Application by VPI Immingham B Limited for an Order Granting Development Consent for VPI Immingham OCGT Project

The Examining Authority's Written Questions and Requests for Information (ExA WQs)

Issued on Thursday 15 August 2019

Drawing Title
OTHER DEVELOPMENTS CONSIDERED FOR CUMULATIVE IMPACTS FIGURE 17.1

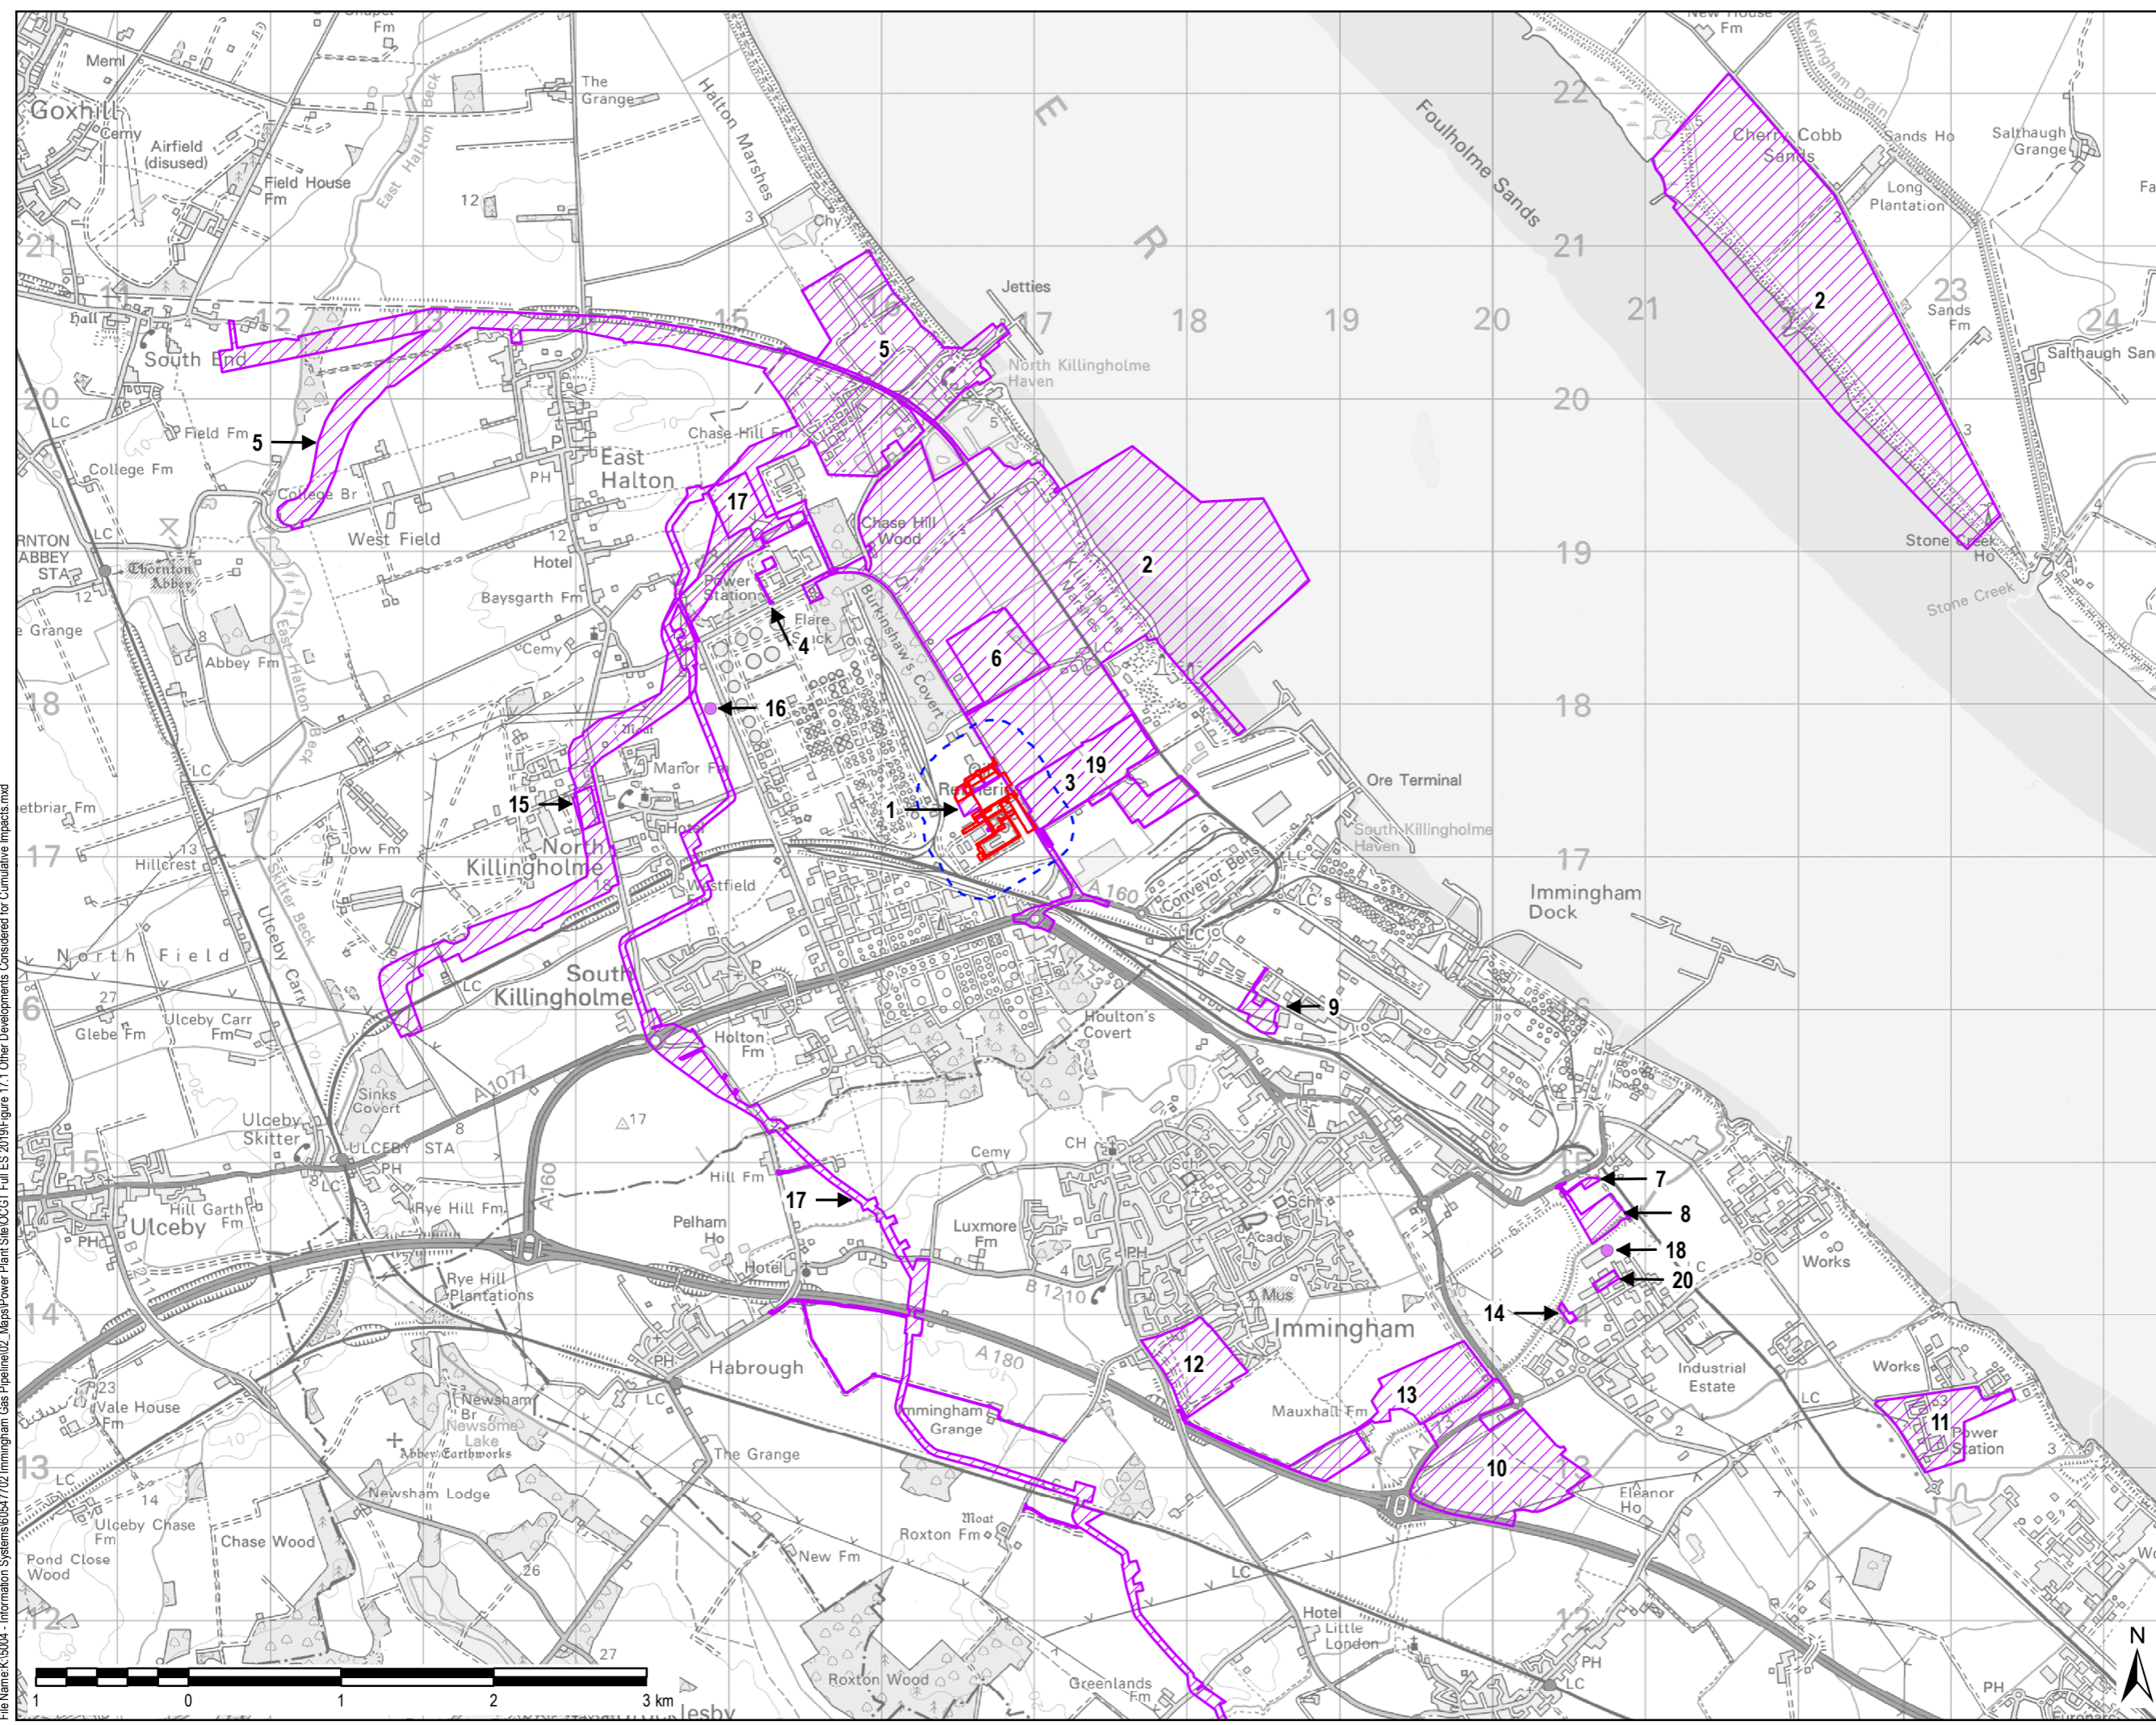
Ref No.	Respondent:	Question:
	<p><i>baseline</i></p> <p>Applicant</p>	<p>include committed developments. The committed developments are stated in [APP-046] ES Chapter 17 Cumulative and Combined Effects and [APP-073] Figure 17.1. It is noted that the construction traffic modelled data utilises a 2015 baseline.</p> <p>Can the Applicant explain why more up to date information has not been used and what, if any, effect more up to date data might have on the assessment findings?</p>
<p>Q1.1.10</p>	<p><i>Operational effects/Isopleth maps</i></p> <p>Applicant</p>	<p>Can the Applicant state whether the meteorological data with regard to wind direction shown in [APP-78] Figure 6A.1 Windrose for Humberside Airport which is sourced from the Humberside Airport 9.5km southwest of the proposed development; has been manipulated to be more representative of the localised Immingham area (eg taking into account local topography and structures), and any assumptions and limitation that arose in manipulating the data?</p> <p>If the data has not been manipulated to be more representative of the localised Immingham area, can the Applicant explain how this could affect the accuracy of the isopleth maps and the subsequent outcome of the assessment used to assess the operational effect of human and ecological receptors during the operational phase of the proposed development?</p>
